DRB CASE ACTION LOG (FINAL PLAT)

DRB Application No.: 05DRB-01092 (FP)

Project # 1004267

Project Name: LANDS OF MANUEL & CATHY GONZALES

SHEET 2 OF 2

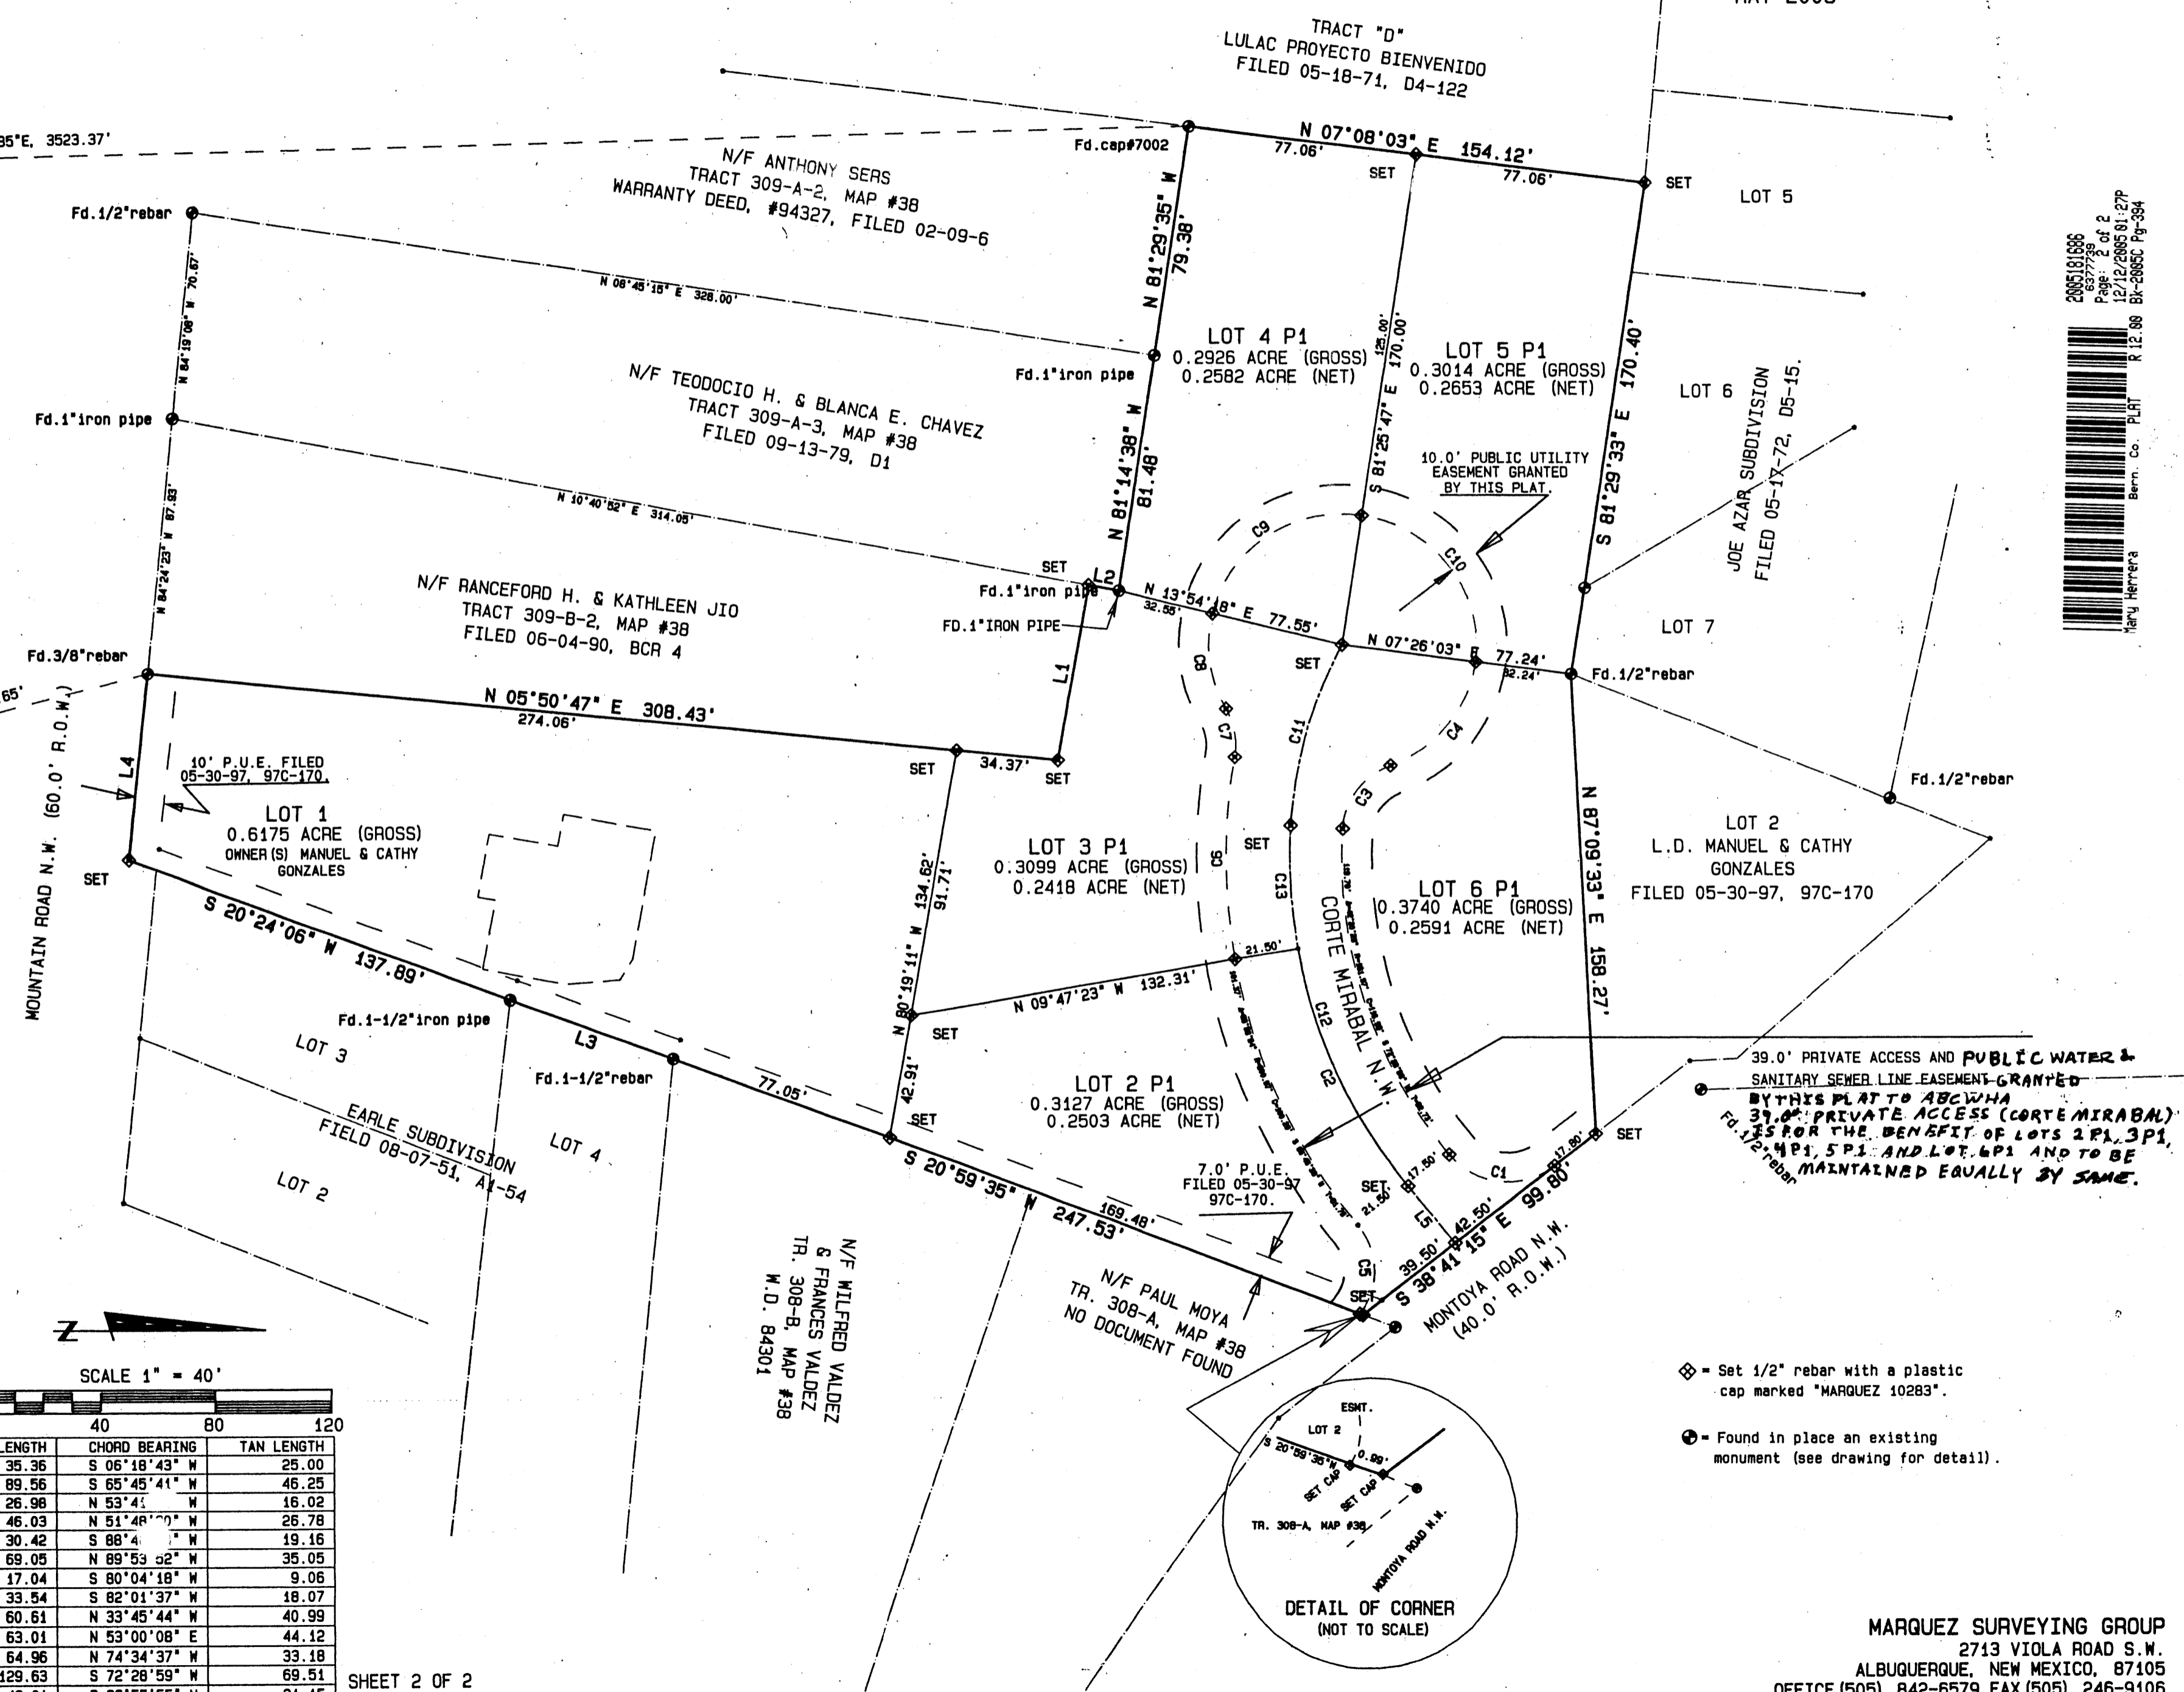
- TRANSPORTATION: NEED MAINT. & BENEFICIALS OF
CORTE MIRABAL
 Record Plat
- UTILITIES: Change Note to Read: Public Water & W
sanitary sewer line easement granted
by this plat to ABC WPA
 Record Plat
- CITY ENGINEER / AMAFCA: _____
- PARKS / CIP: _____
- PLANNING (Last to sign): Record Plat
